2024/0844

Address: 10 Kexbrough Drive, Kexbrough, Barnsley, S75 5EY

Description: 1st floor side extension (above existing single storey side extension), and single storey rear extension to 2 storey detached dwelling.

Proposed Elevations 1:100 @ A1

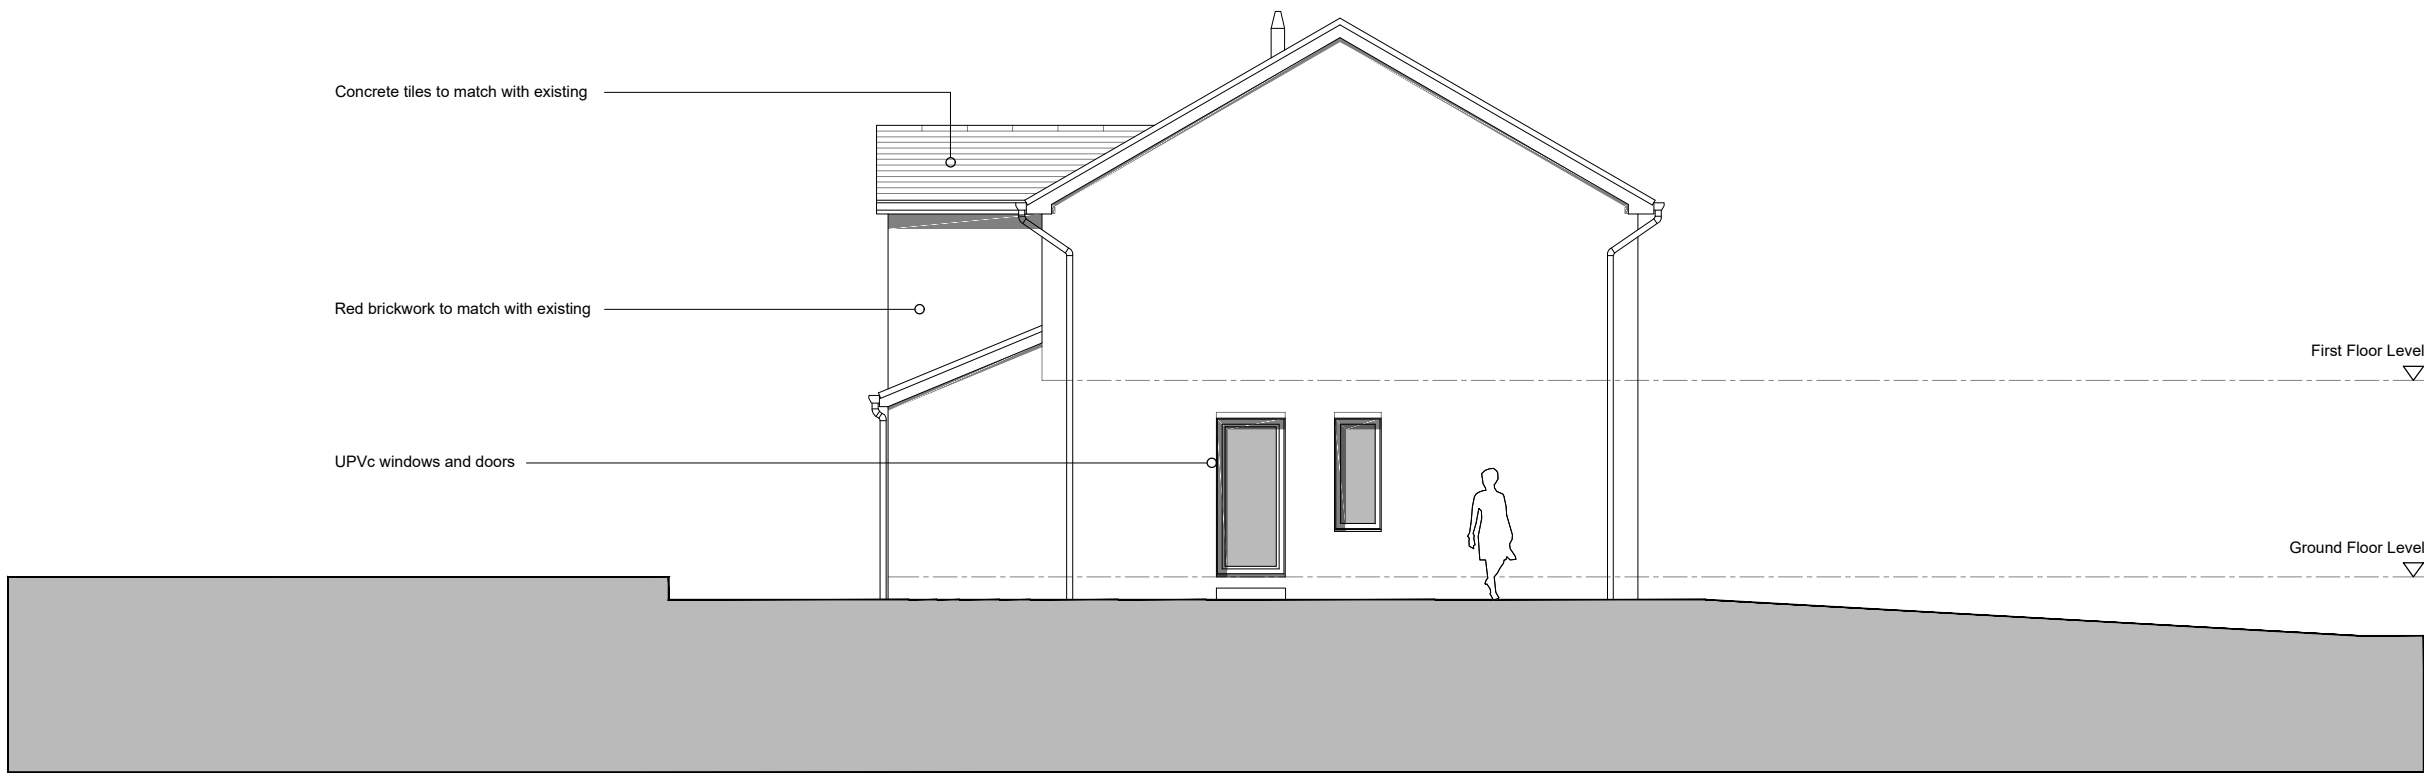
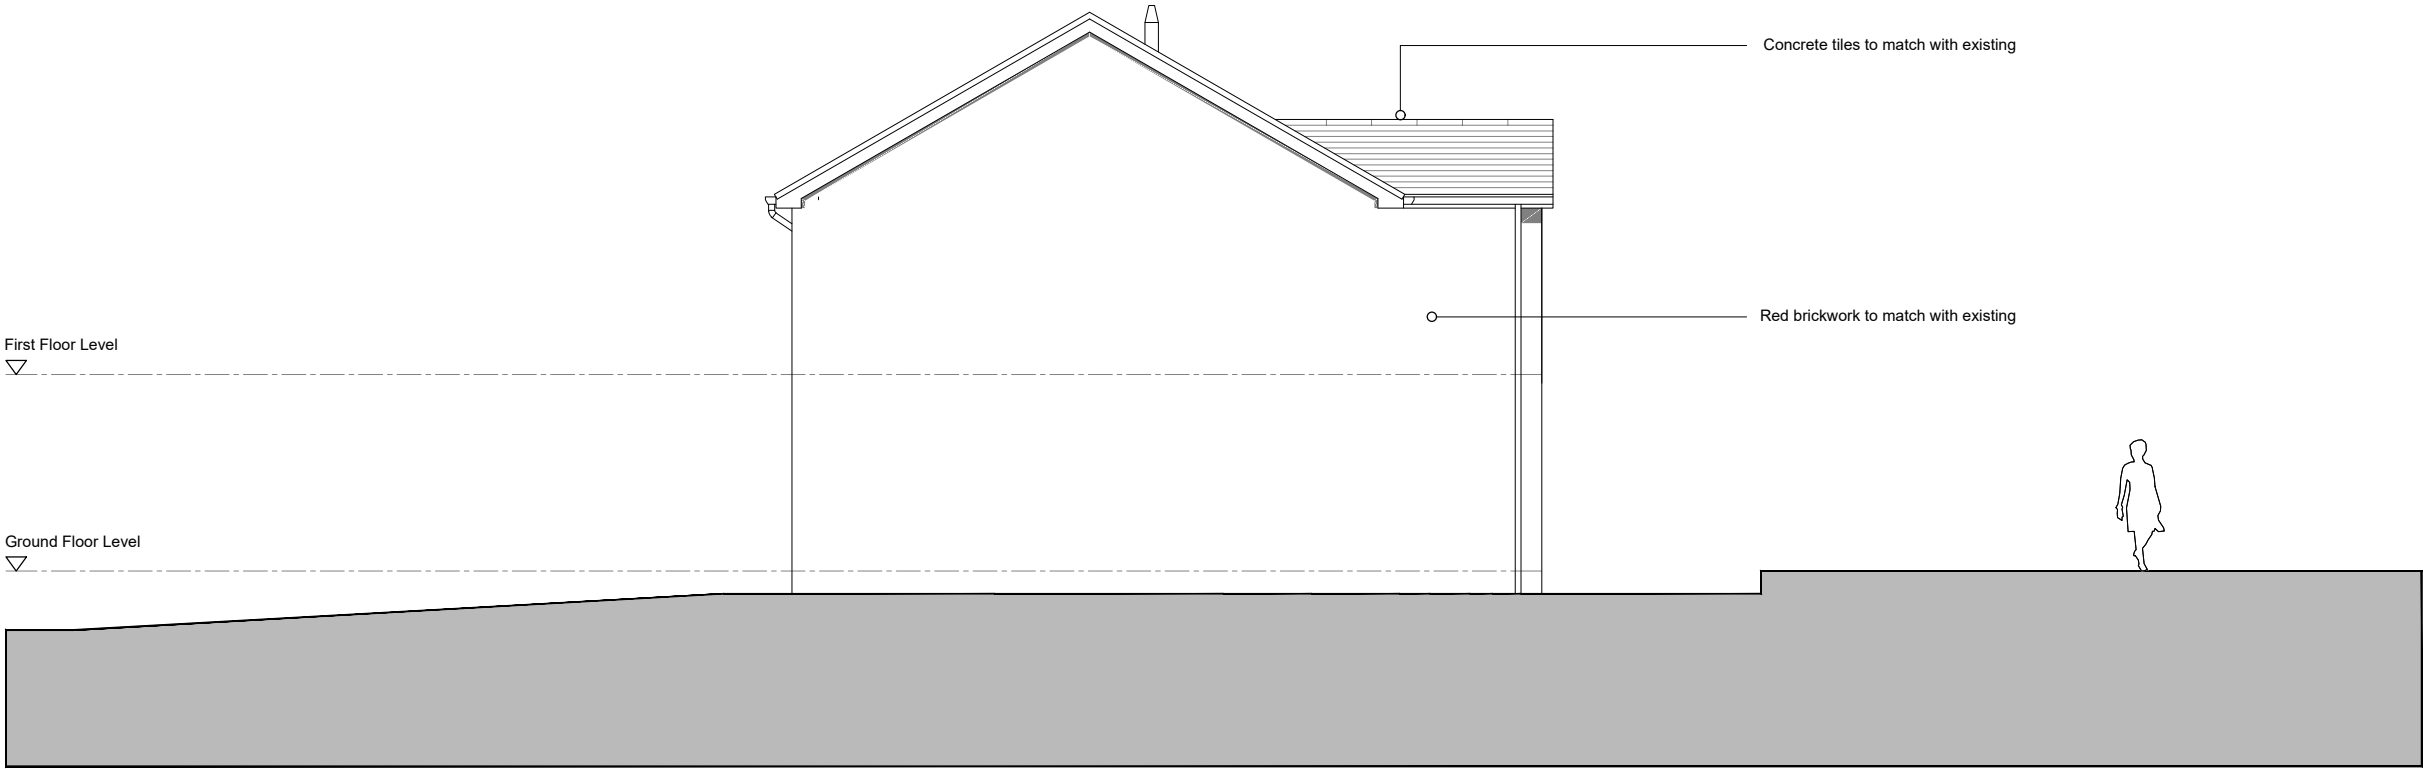
To comply with local policy, a step down of the roof and a setback of the first floor have been included in revised plans. There are some other examples of similar extensions within the area, some without the required setback or step down. With subordination demonstrated, the potential terracing effect has been reduced but not completely eradicated. A smaller garage door replaces the current door, reducing the viability of the garage for a vehicle but maintaining a garage door, which are quite prominent within the street scene. The addition of a front canopy, along with the use of matching materials and a similar style roof, help integrate the proposal into the existing character of the dwelling and position within the street scene.
